WEST SUSSEX COUNTY COUNCIL CONSULTATION

TO:	Arun District Council FAO: Simon Davis
FROM:	WSCC - Highways Authority
DATE:	10 April 2019
LOCATION:	Babsham Business Centre Babsham Lane Bersted PO21 5EL
SUBJECT:	BE/30/19/PL Retention of secure containers, welfare facilities & secure fencing together with associated landscaping works. More information.
DATE OF SITE VISIT:	N/A
RECOMMENDATION:	Advice
S106 CONTRIBUTION TOTAL:	N/A

DRAWING TITLE
SITE LOCATION AND BLOCK PLANS

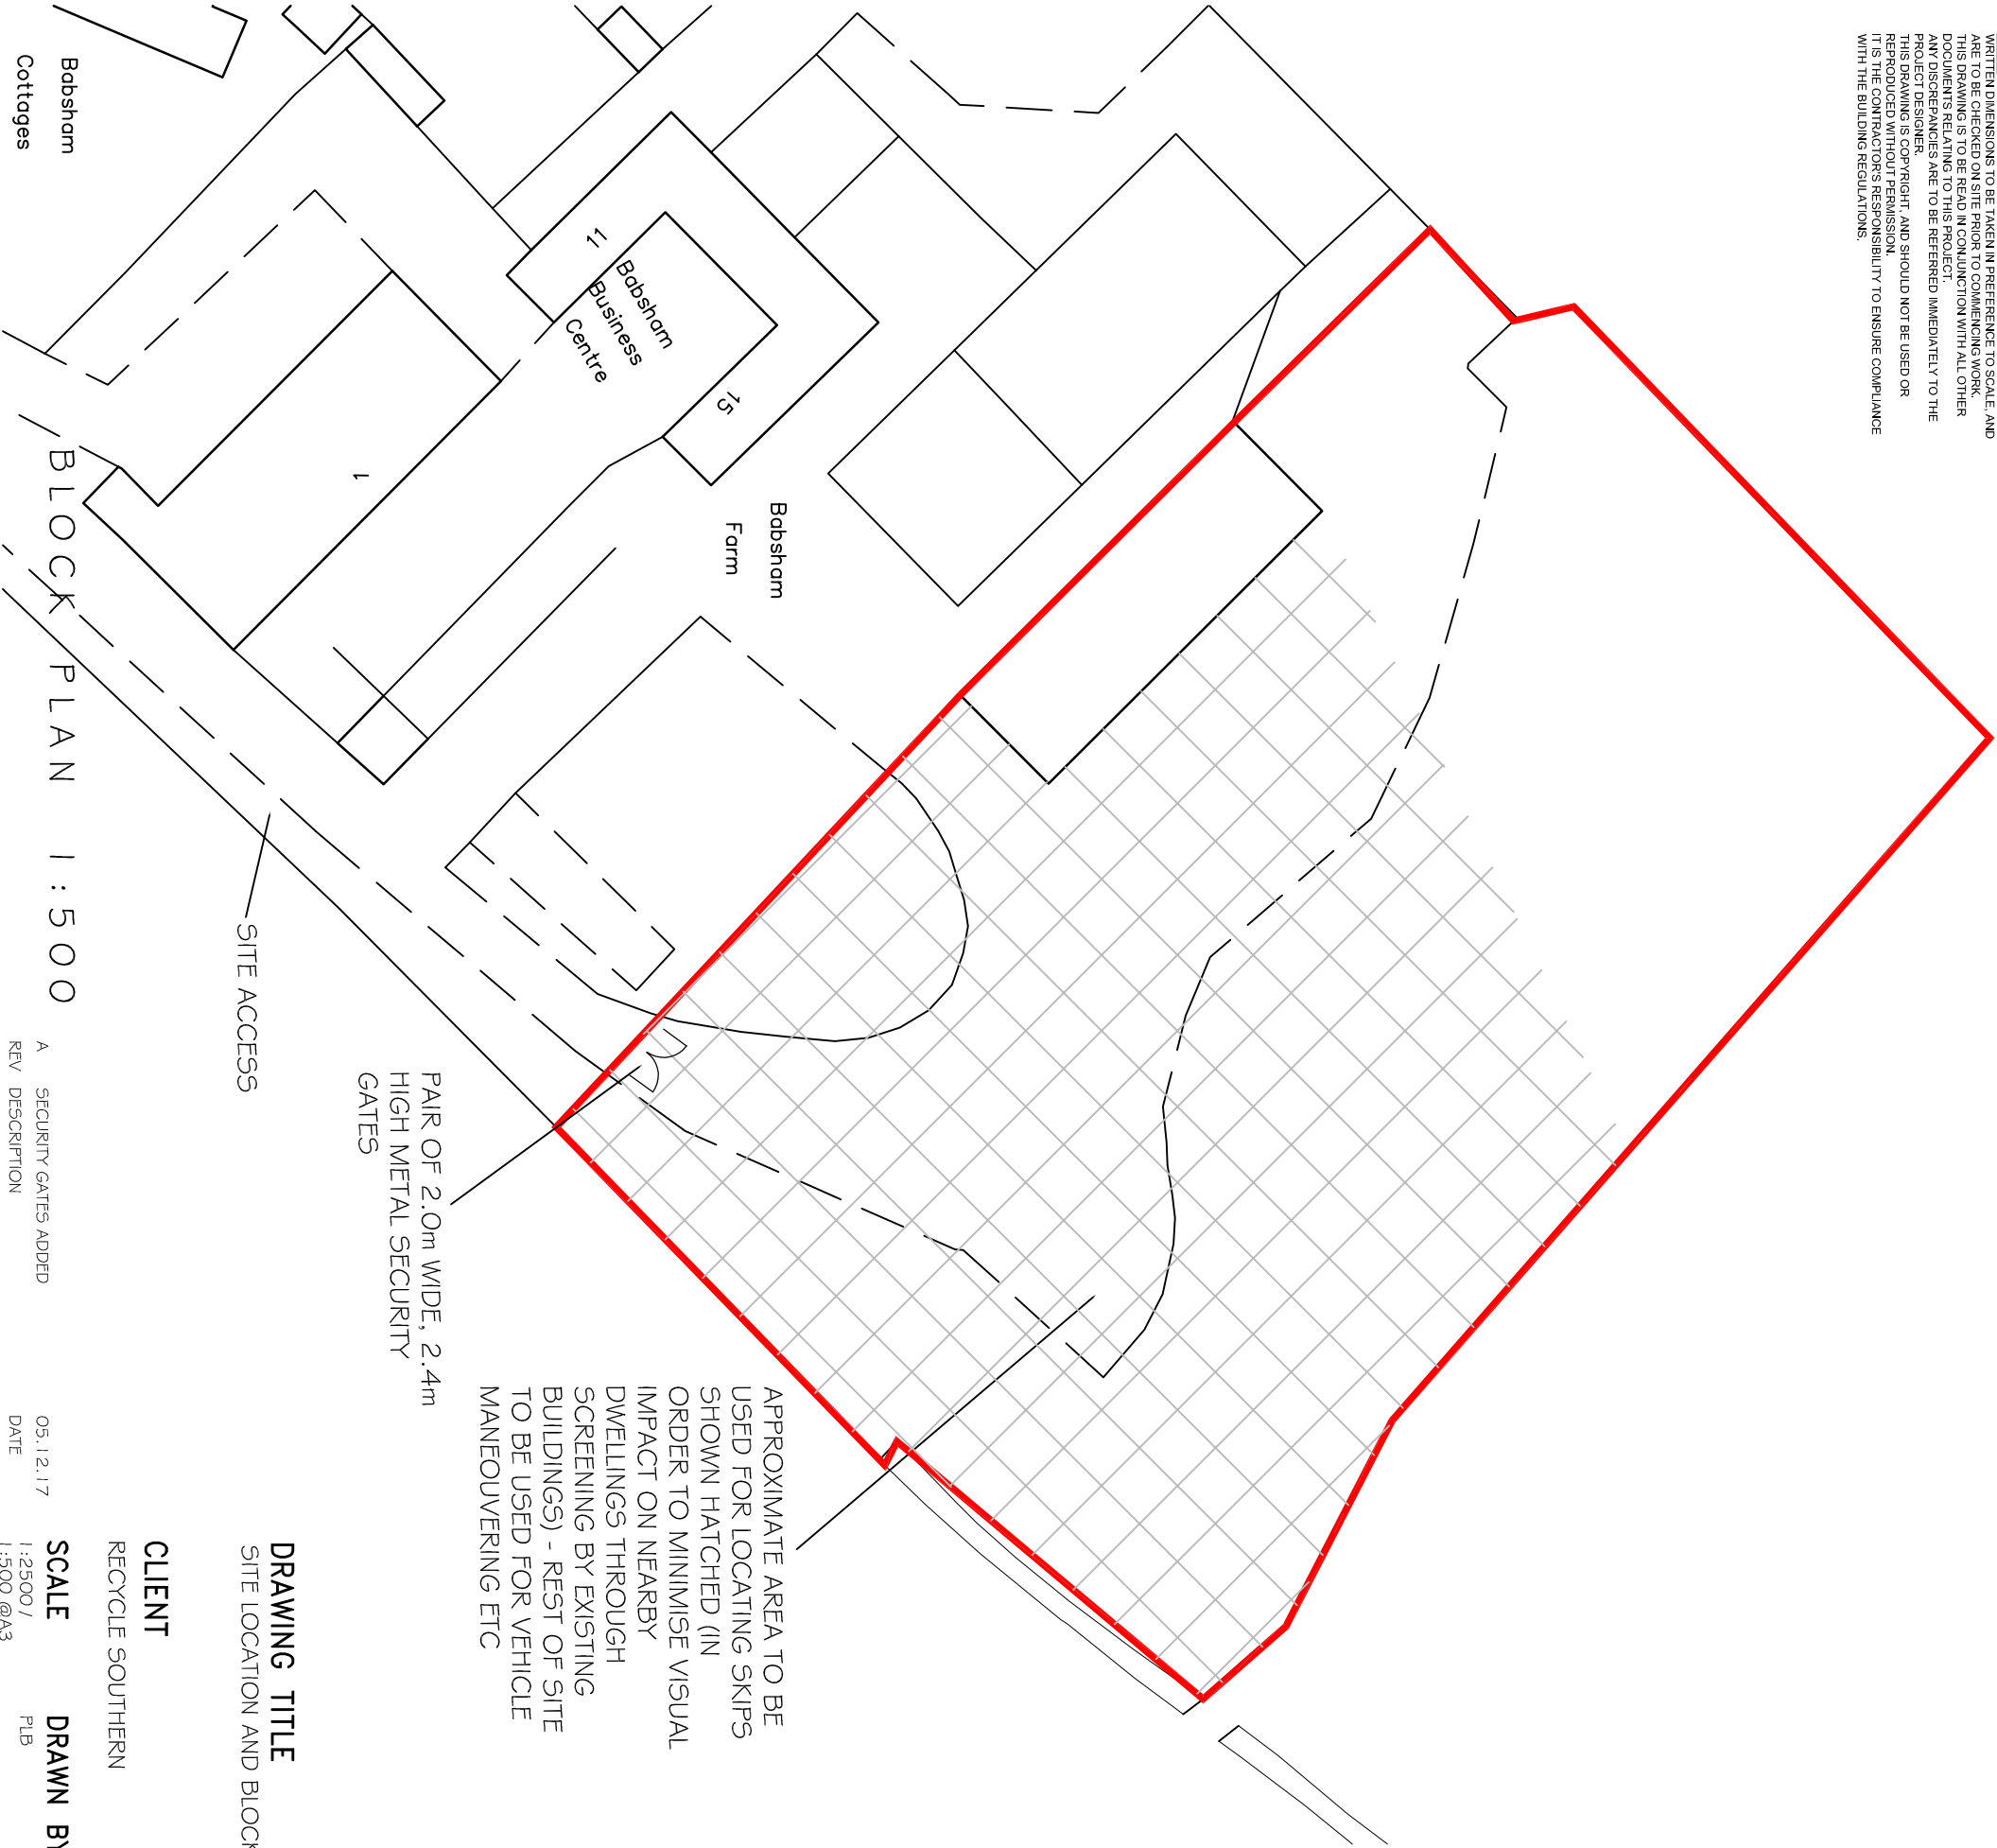
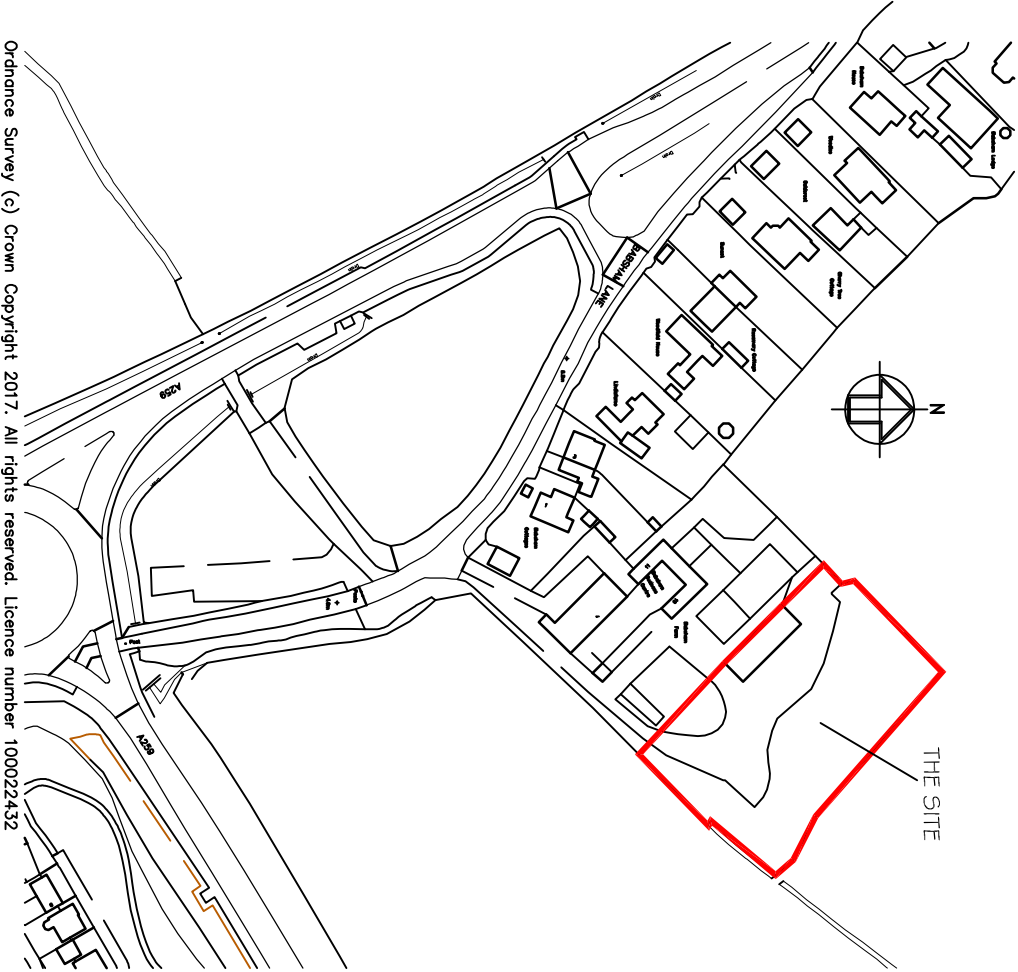
As previously stated in the LHA's first response, this application proposes no alterations to the existing access arrangements onto Babsham Lane. The site currently operates a storage (B8) use and the retention of storage containers is not anticipated to result in a material increase in vehicle movements to or from the site over the potential of the existing storage use of the site. In addition, Babsham Lane also currently serves the existing business centre and a number of dwellings. An inspection of data supplied to WSCC by Sussex Police over a period of the past five years reveals that there have been no recorded injury accidents within the vicinity of the site as result of the road layout, or involving any HGVs entering or exiting the site. Therefore there is no evidence to suggest that the existing access is operating unsafely or that this proposal would exacerbate an existing safety concern.

The location of the storage containers and welfare facilities within the site still provides sufficient space for vehicles to turn on site and exit onto the public highway in a forward gear.
